**April 5, 2006  
DRB Comments**

**PROJECT # 1004784      APPLICATION # 06DRB-00402**

**RE: Lot 39, Alameda Business Park/spbp**

Re: Request for Site Plan for Building Permit for lot number 39 of the Alameda Business Park

**SITE PLAN**  
 SCALE: 1" = 20'-0"

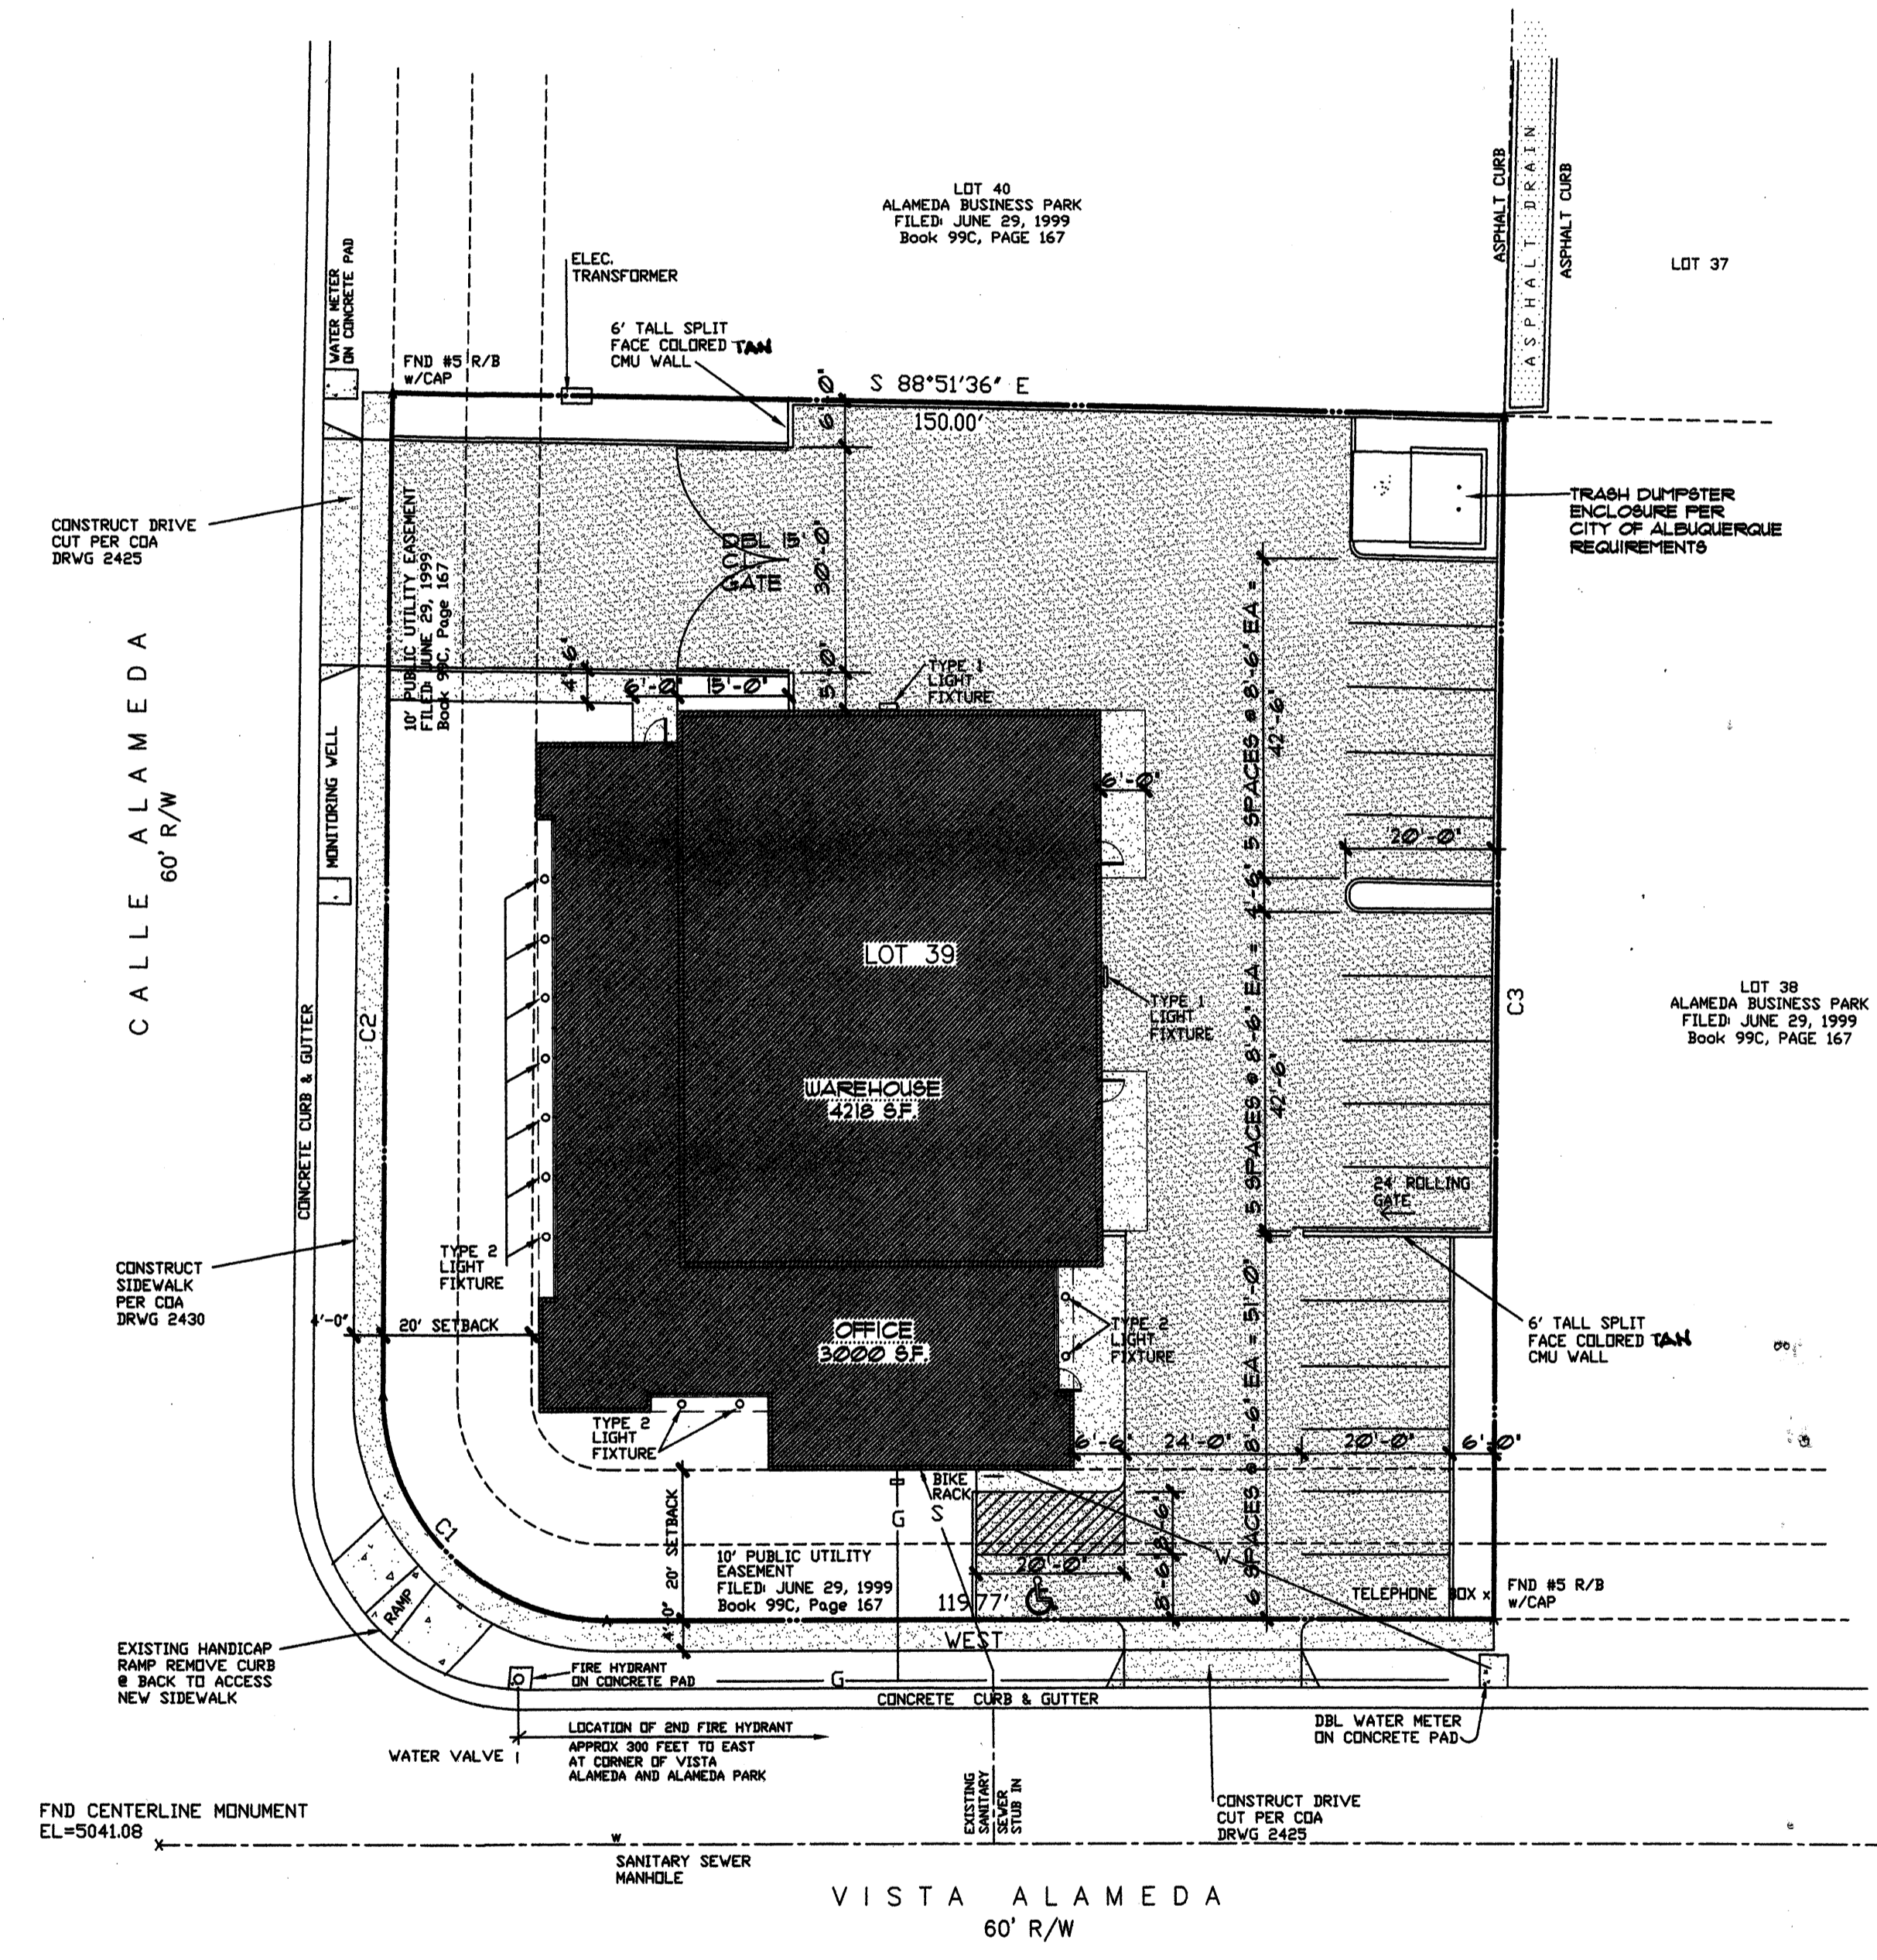
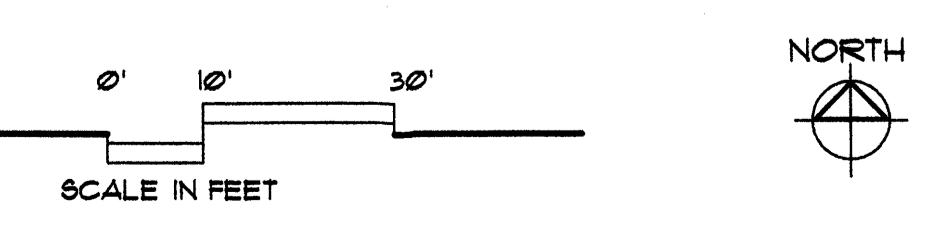
Because this is not an EPC approved site plan, the first paragraph in the signature block should be eliminated.

- ✓ 1. The Conceptual Utility Plan is missing.
- ✓ 2. The existing & proposed easements' identification is missing from the Landscape plan.
- ✓ 3. The color of the split faced block wall is not identified on the site plan.
- ✓ 4. The property lines are not clearly identified on the Landscape Plan.
5. Some of the "Notes" on the Landscape Plan need revising:
  - ✓ • Maintenance of landscape & irrigation system provided by owner.
  - ✓ • This plan is to comply with *City of Albuquerque Water Conservation Landscaping and Waste Water...*
  - ✓ • Landscape areas to be mulched with gravel (*color & size?*) at 3" *minimum* depth over filter fabric.
  - ✓ • Approval of the Landscape Plan does not constitute or imply *exemption from the water waste provisions of the Water Conservation, Landscaping & Water Waste Ordinance.*

- ✓ 6. Materials & colors of windows, doors & framing appear to be missing from Building Elevations.
7. Signage to identify the business occupying the building must be planned. Nothing is provided on the site plan. Signage on the building? Only one building mounted sign per business is allowed and it cannot exceed 15% of the façade area on which it is mounted.
- ✓ 8. Alameda Business Park Master Plan:
- Add a statement about screening roof mounted equipment from public view to the site plan.

As requested the first paragraph in the signature block has been eliminated.

comment 1. The conceptual utilities are shown on page C-1 Site Plan.

comment 3. The color of the split face block wall has been added to page C-1 Site Plan

comment 8. A statement about screening roof mounted equipment from public view has been added to both sheet C-1 Site plan and A-1 elevations.
